## Department of Transportation

April 15, 2020

re: Monument Academy - Updated March/2020 submittals  
Site Dev Plan, Hydraulics - PPR199  
CDR (Road and Roundabout) - CDR201

C2.2

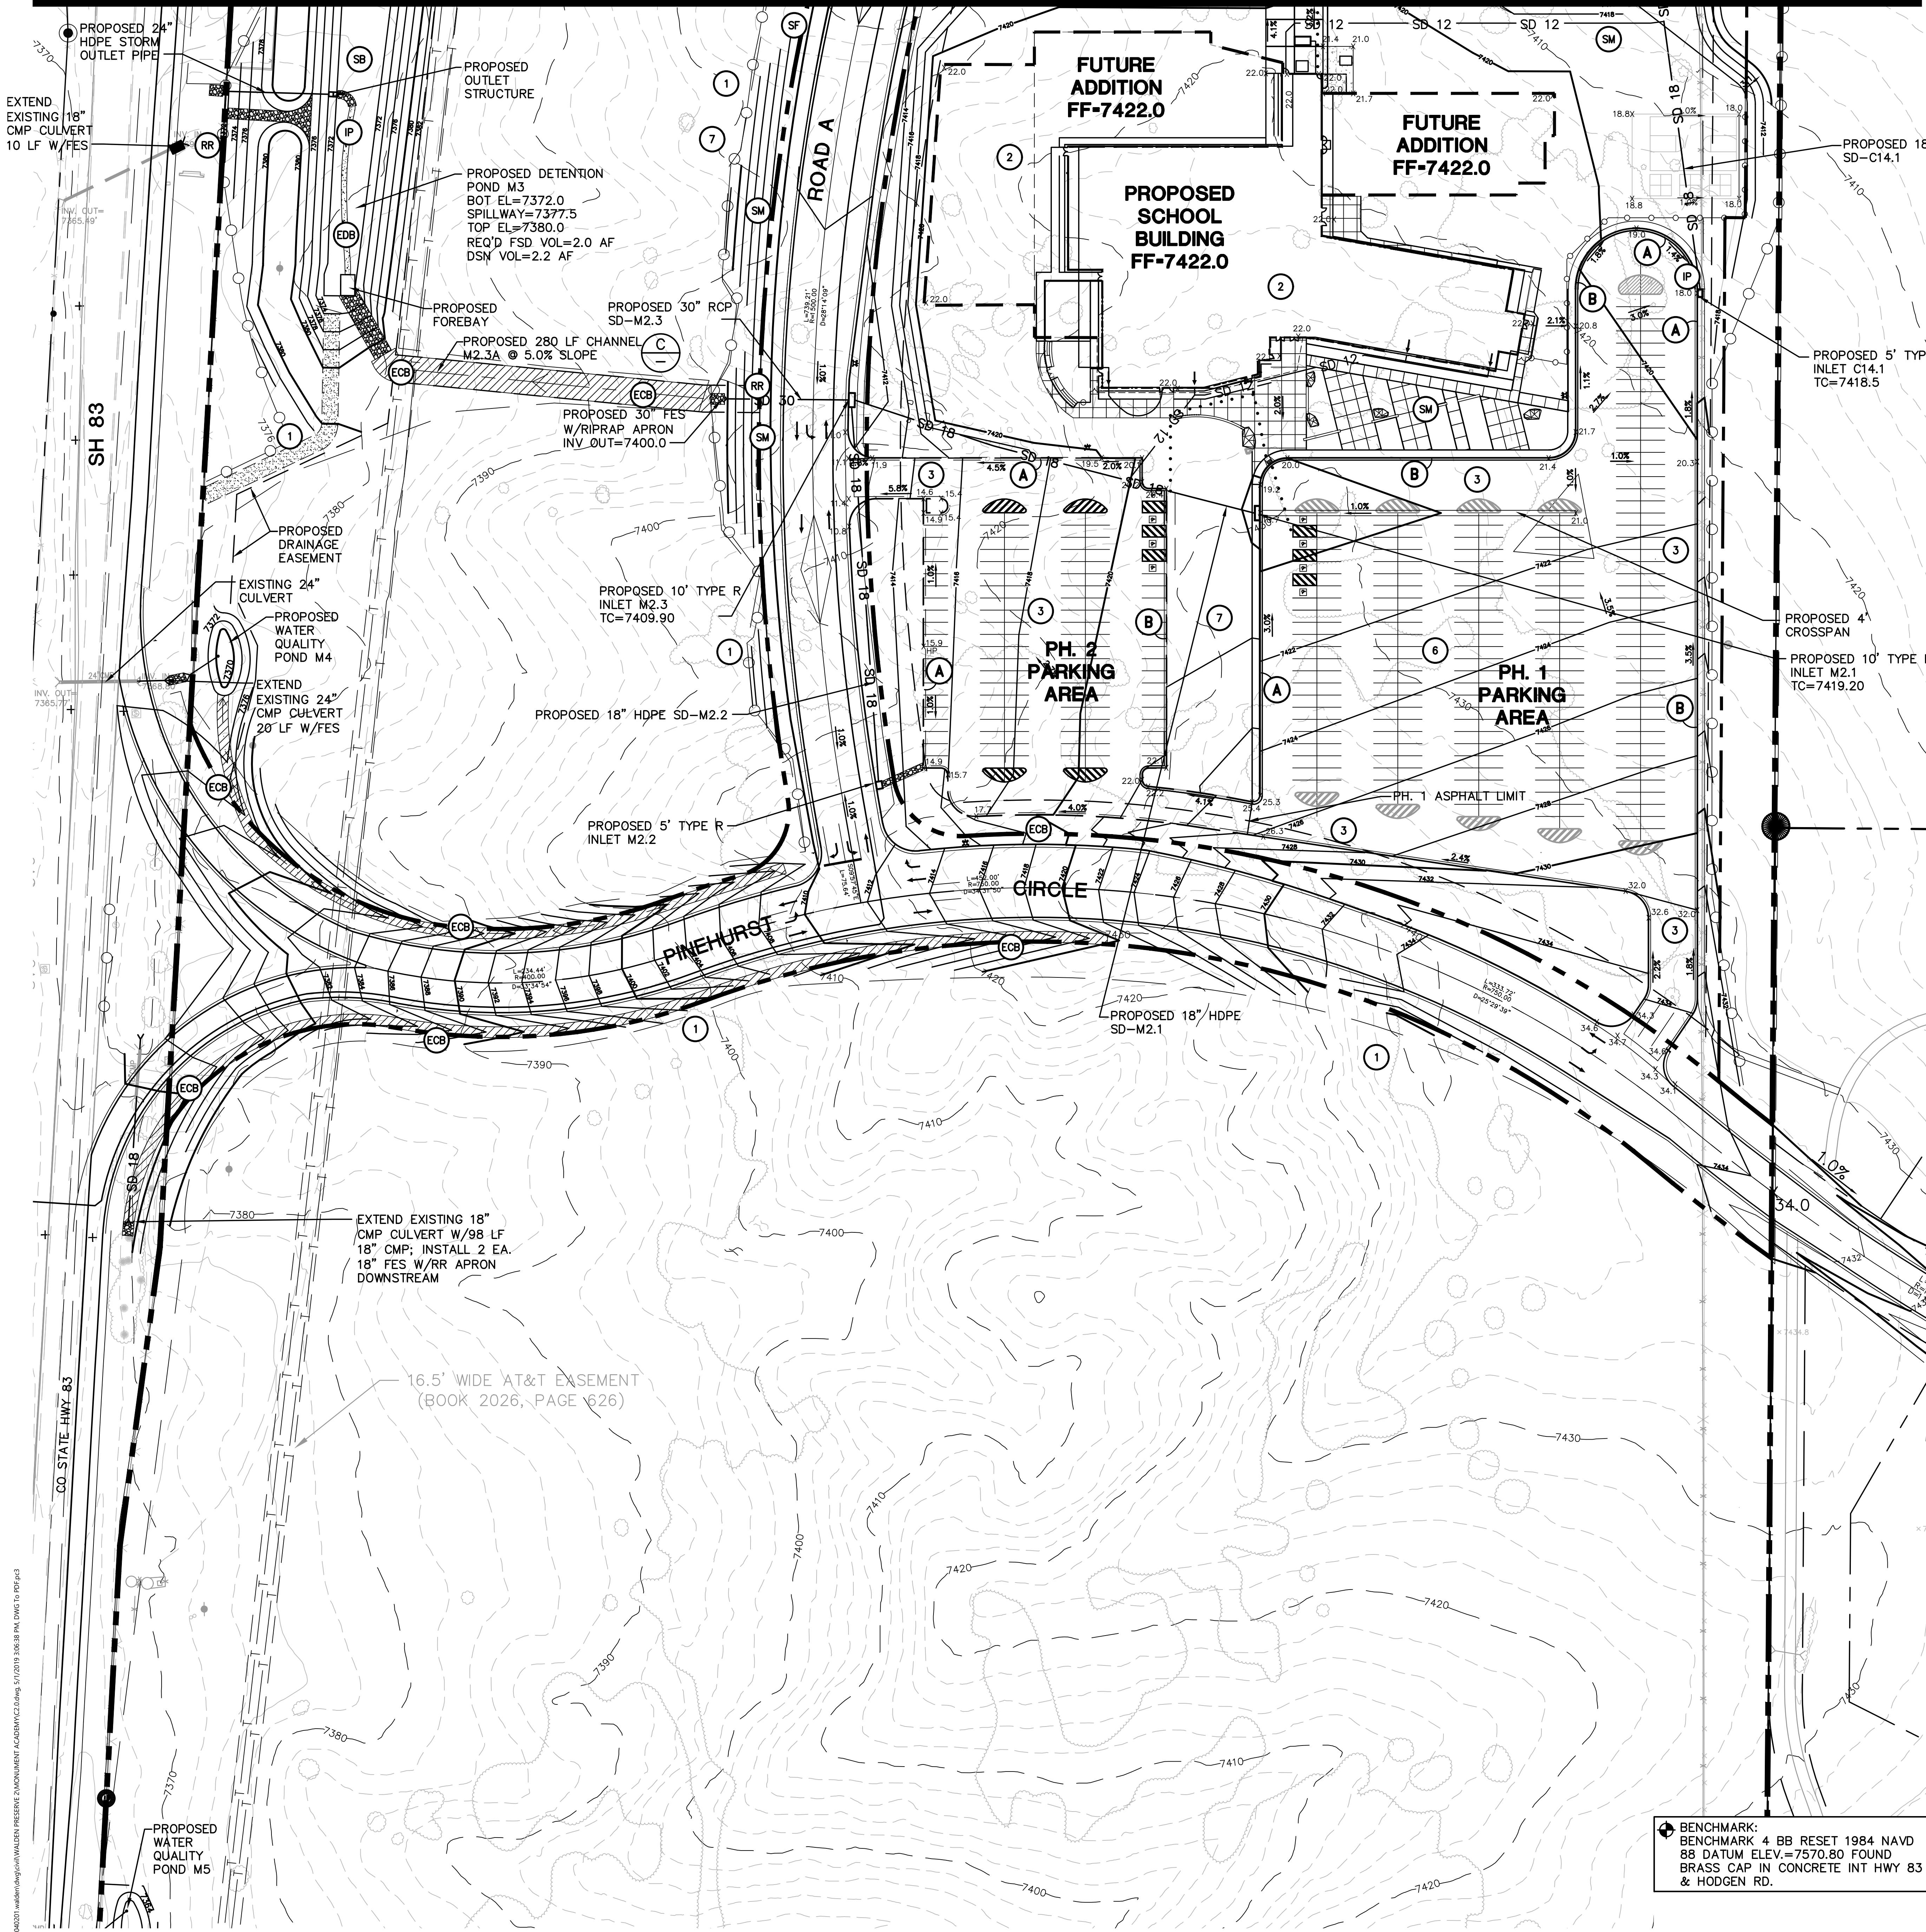
- a) **Detail for SH.C2.2 does not show how the proposed pipe will be connected to the existing pipe. Please revise the detail to show this. The detail provided is for a pipe connection to a manhole. Please address and submit detail back to CDOT.**
